Application Ref: Bicester Gateway Phase 1 - 16/02586/OUT

Proposal: Phase 1 of the proposed new business park ("Bicester Gateway") comprising up to 14,972 sq m (Gross External Area) of B1 employment based buildings, plus a hotel (up to 149 bedrooms), with associated infrastructure, car parking and marketing boards.

I have reviewed the application and would like to make the following comments

Principal Ecologist

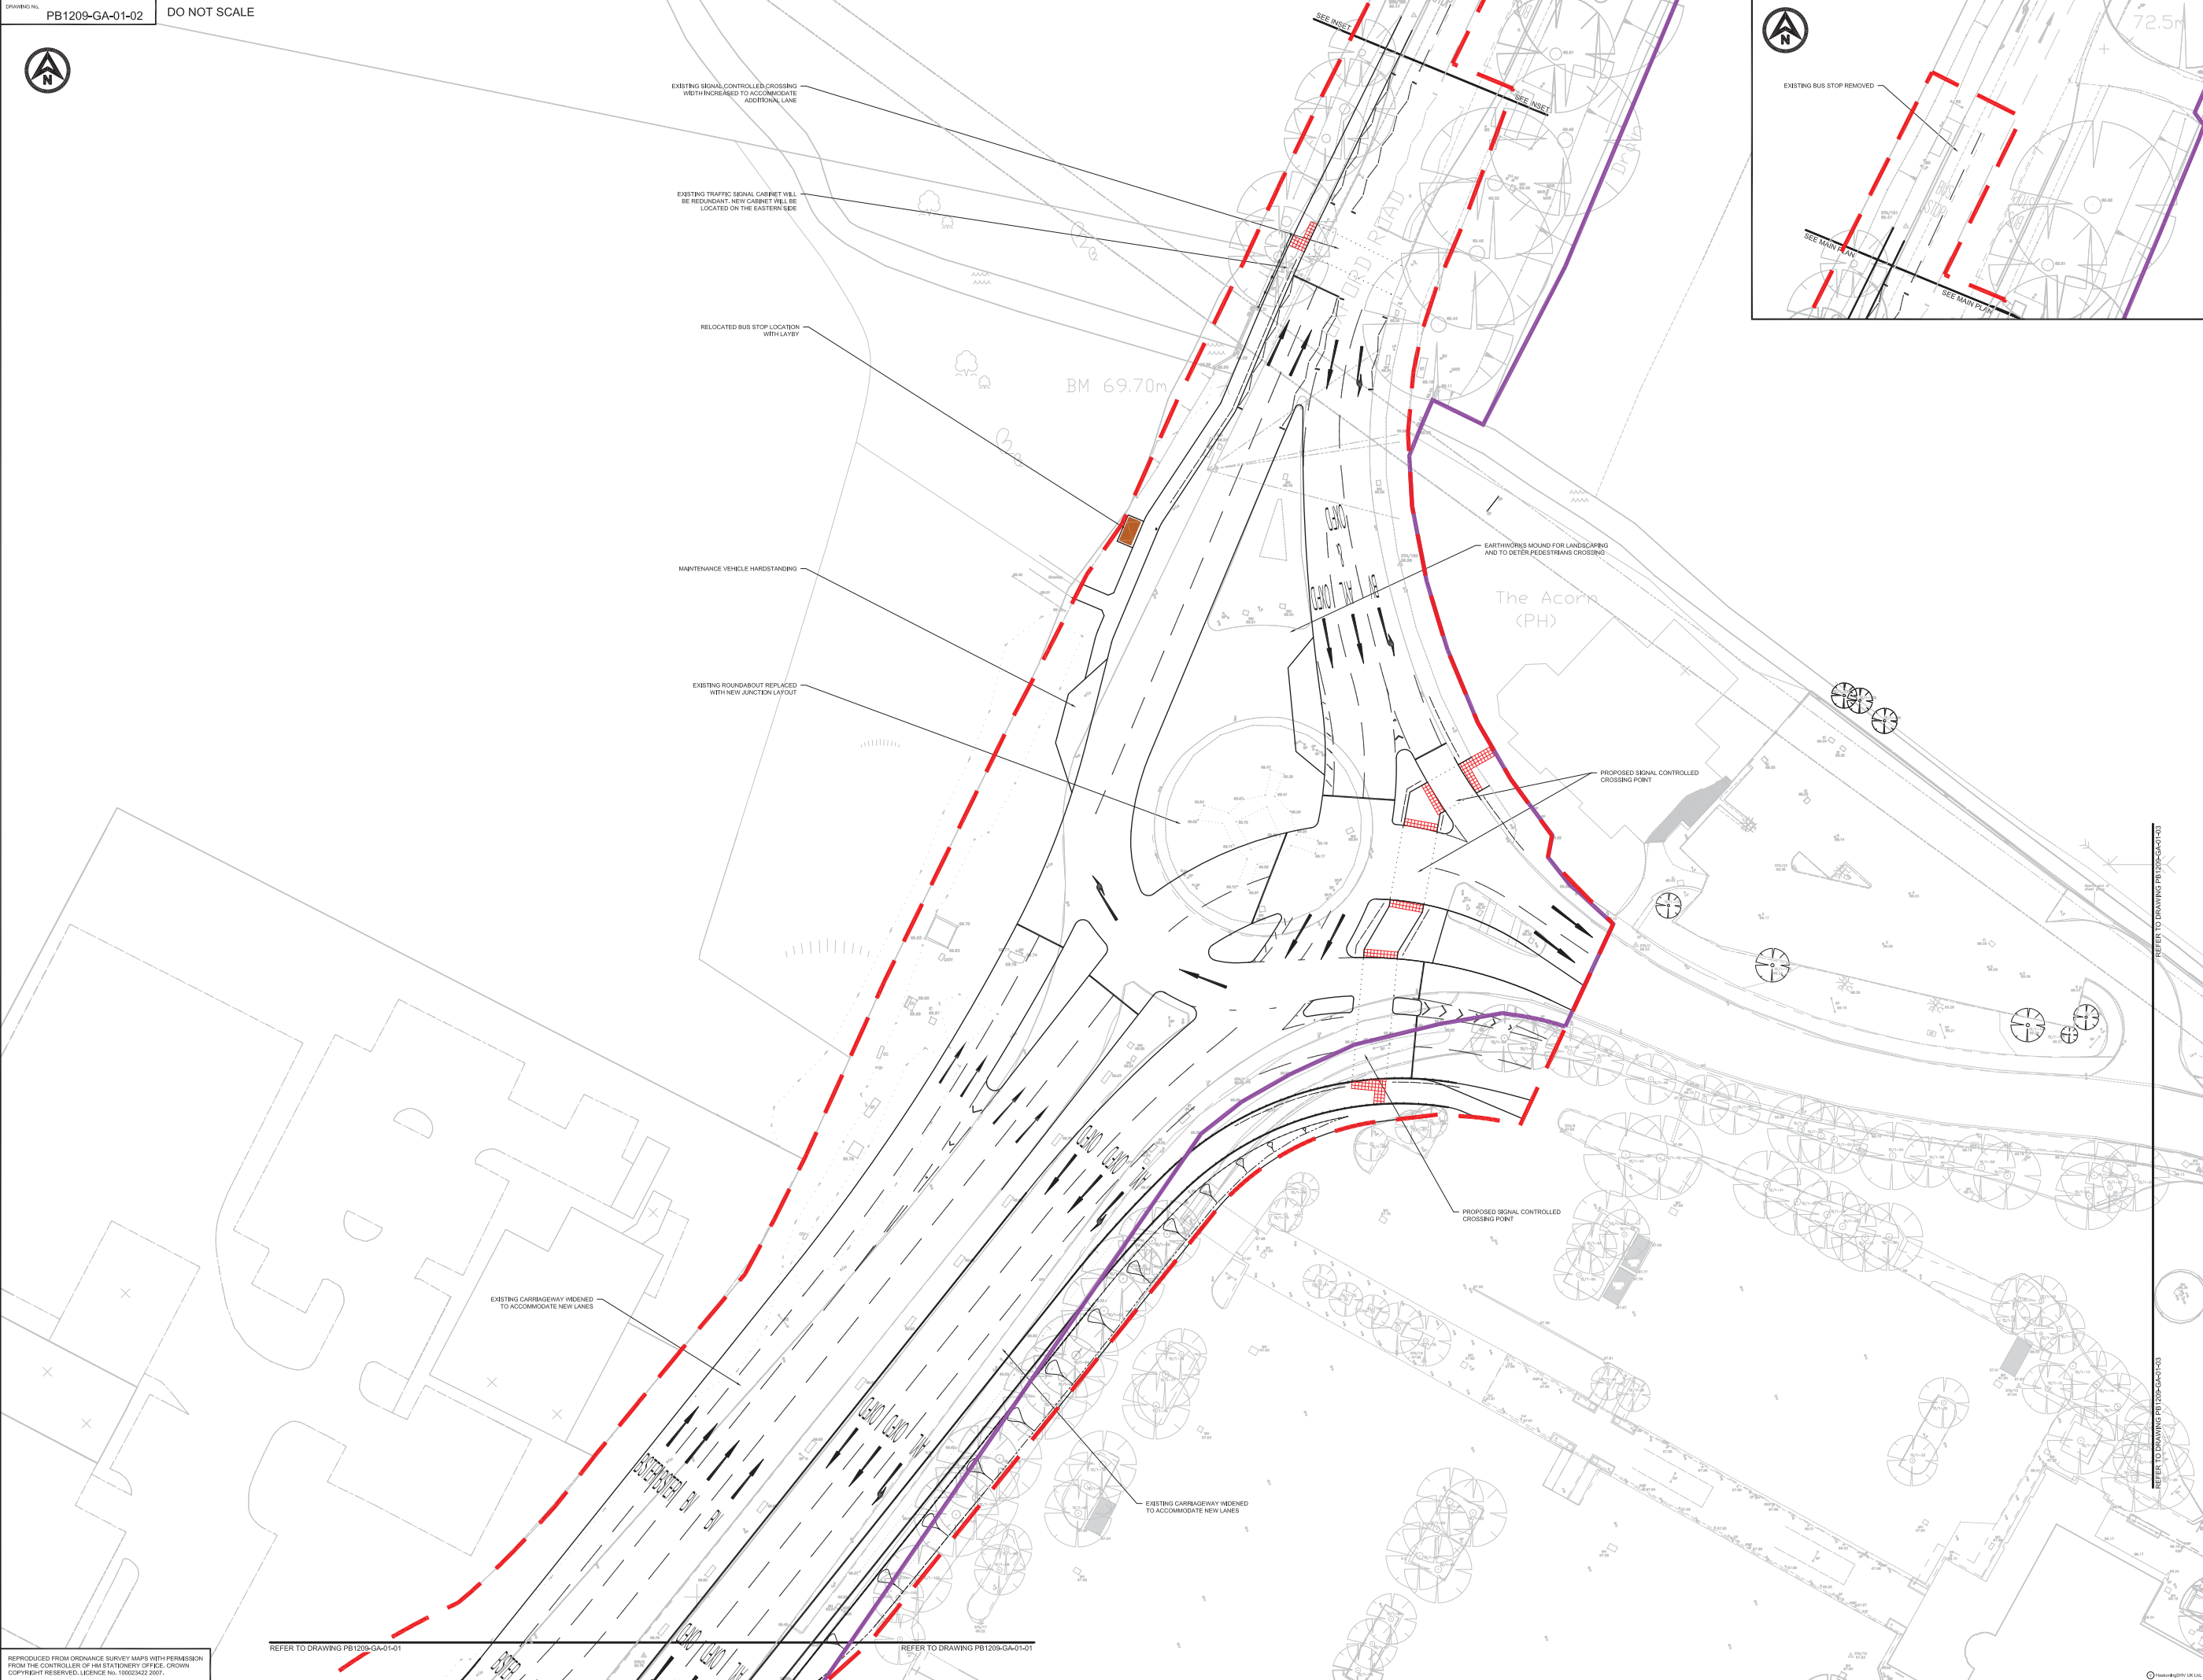
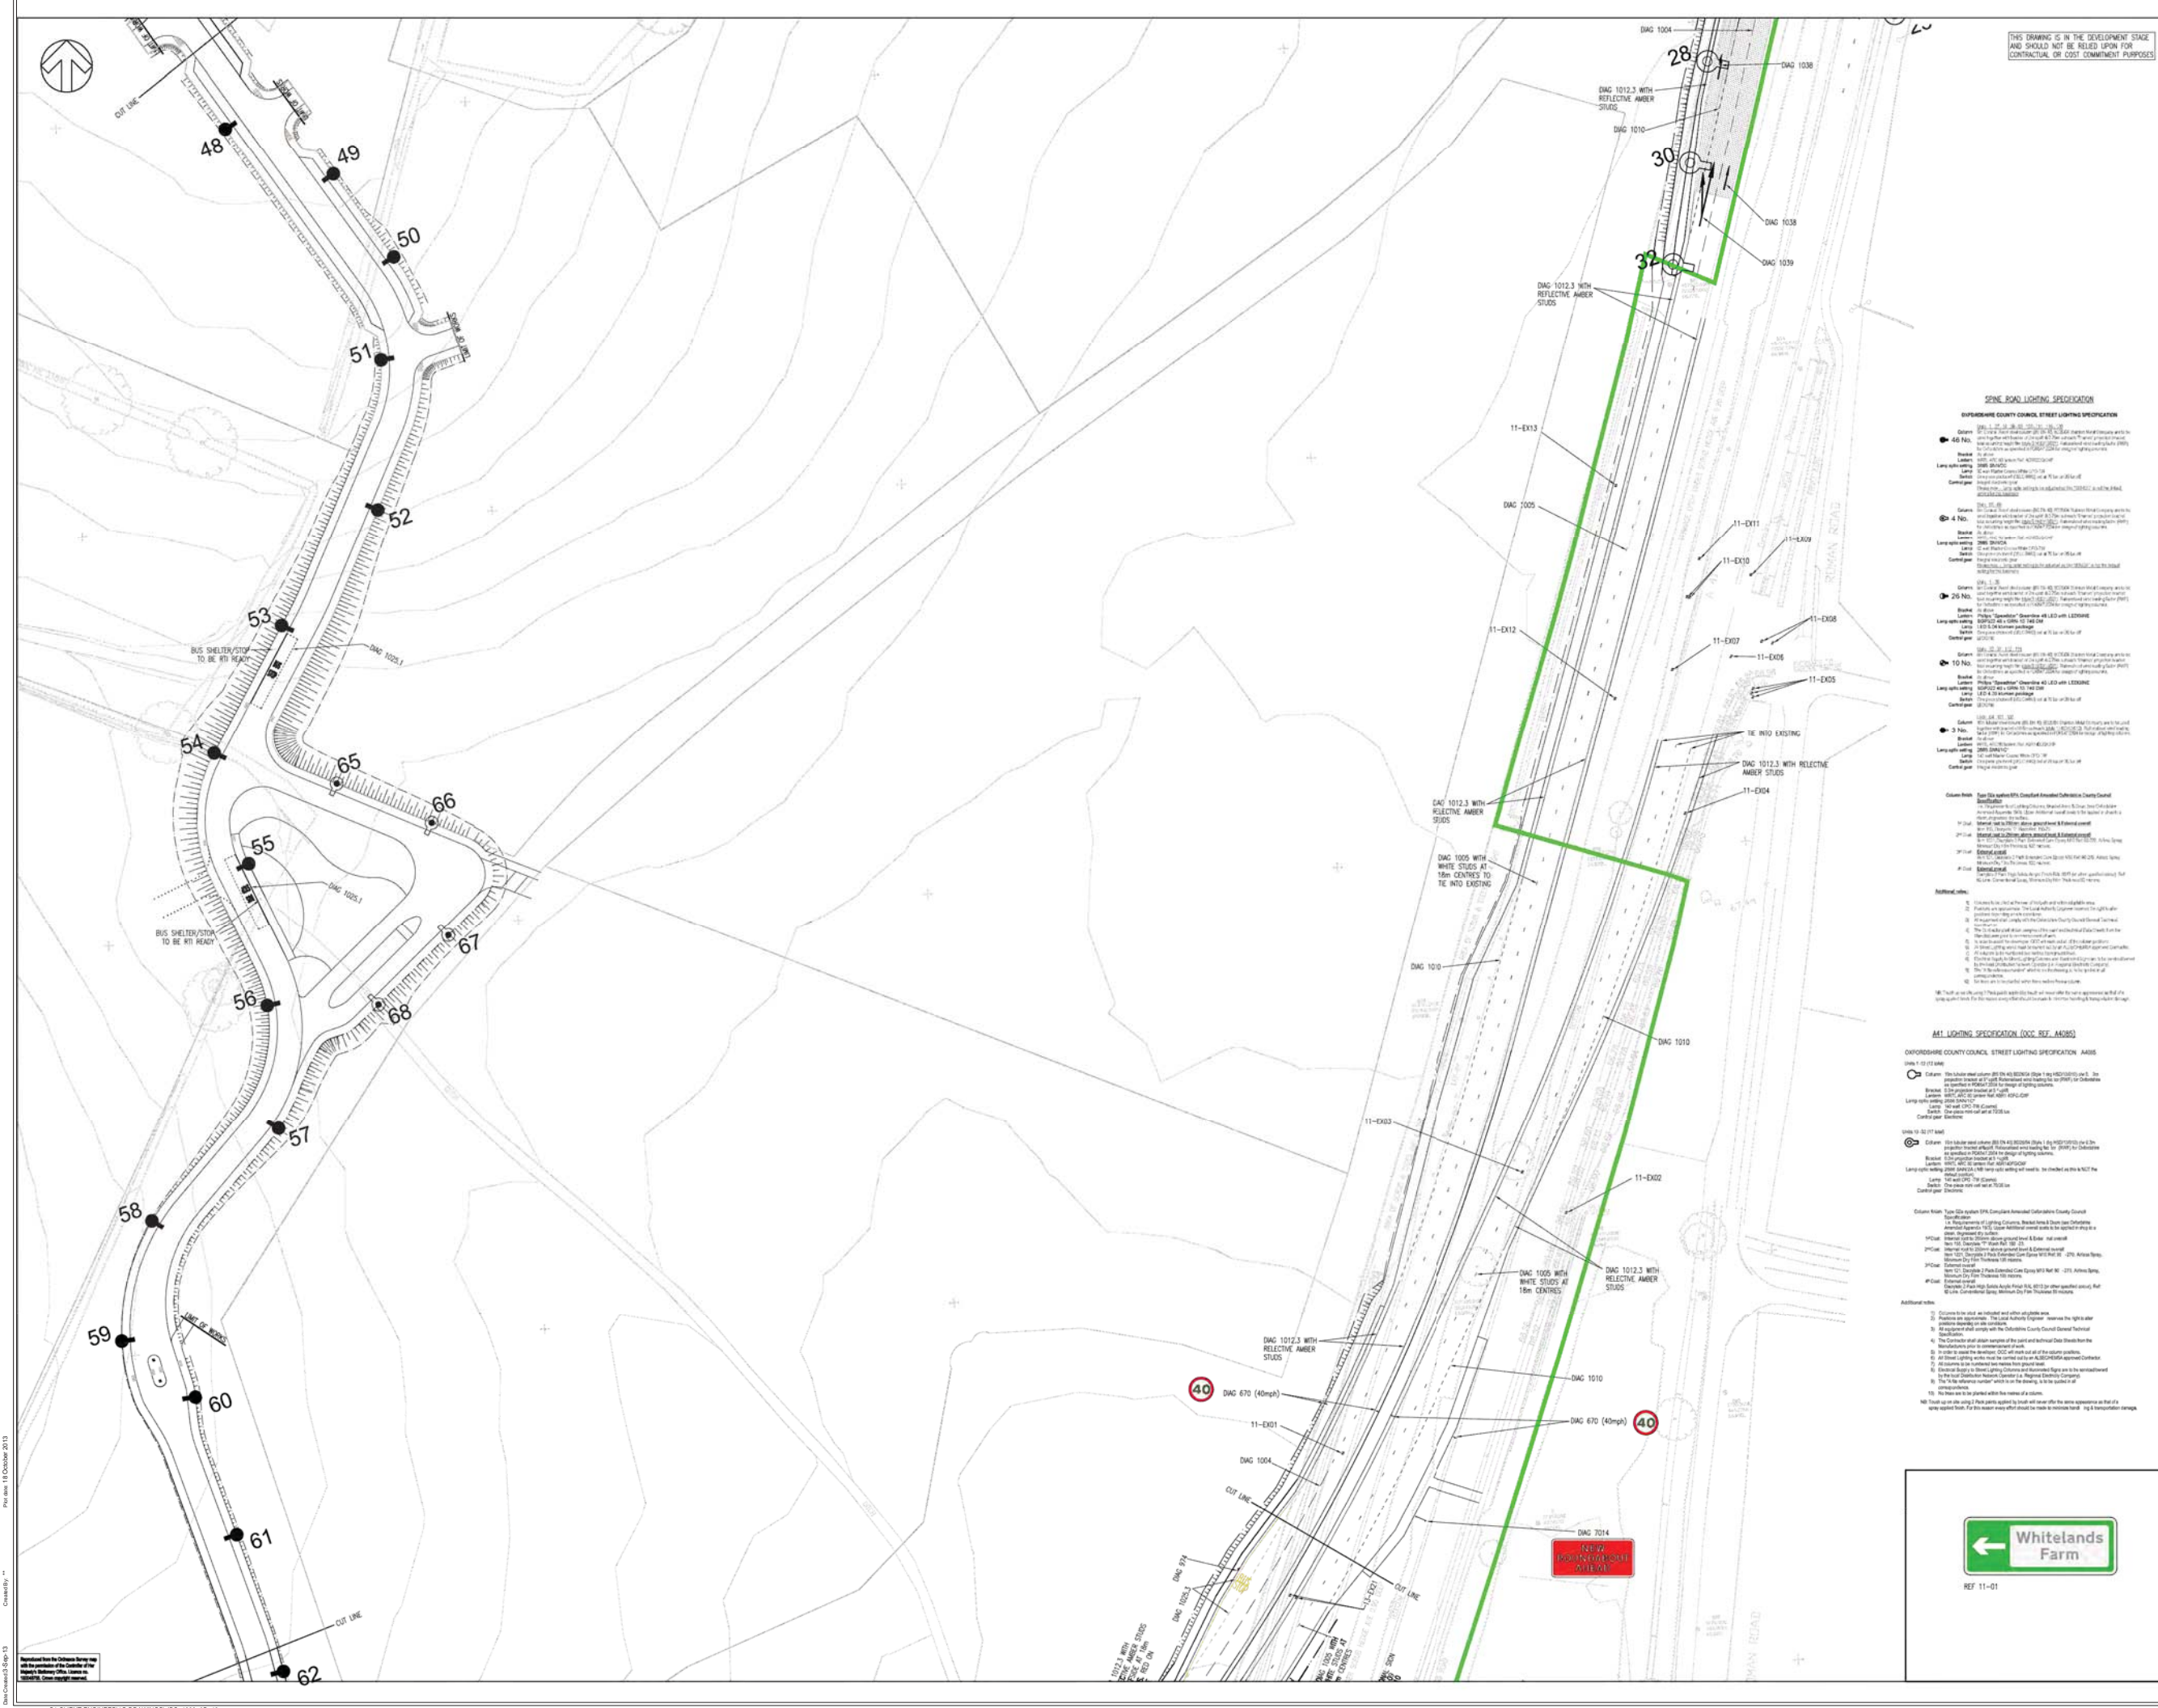
Recommendations: Further surveys are required to determine the presence or absence of the above species and how they use the site throughout the year. The current indicative layout does not illustrate how either Phase 1a or Phase 1b have flexibility to compensate for these species, should they be found to occur on the site at a later date. It is also recommended that the supporting evidence for the great crested newt absence statements within the Ecological Statement is submitted as part of this application.
